Nator Development, Inc
8402 Six Forks Rd
Suite 201
Raleigh, NC 27615

DATE: 5-26-2020
PROJECT: 483 Cypress Circle
LOCATION: SANFORD
RE: GARAGE FOOTING TIE-IN -REVISED PER OWNER REQUEST

FOUNDATION DETAIL

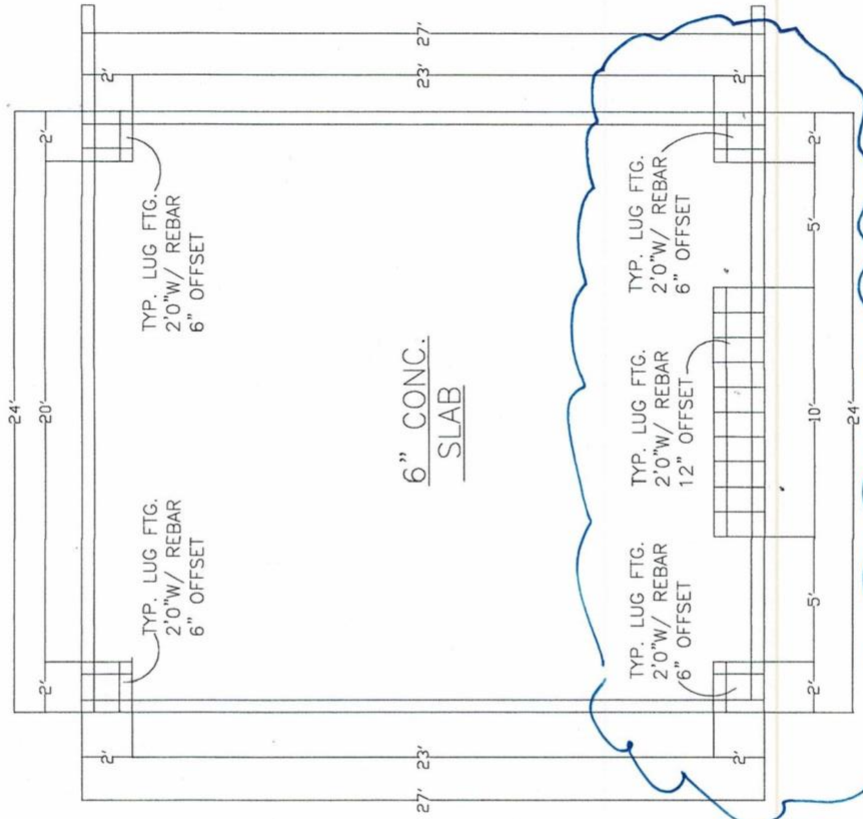
These new footings shall help carry the two story load at the Interior Rear Garage Wall. In general, the new footings are to be reinforced with No. 4 bar, epoxied into the existing footing with an 6"-8" embedment, as shown on the revised foundation detail on Plans G-648, dated 2-15-2020. The footing thickness shall match the existing footing thickness.

In addition, the new wall base plate is to bear fully on the below foundation wall. It is also advised for the said base plate to be secured to the foundation wall with 3/8" steel anchors at 2' o/c with 2' minimum embedment. Foundation wall projection is not necessary if the Base Plate has full bearing on the below foundation wall.
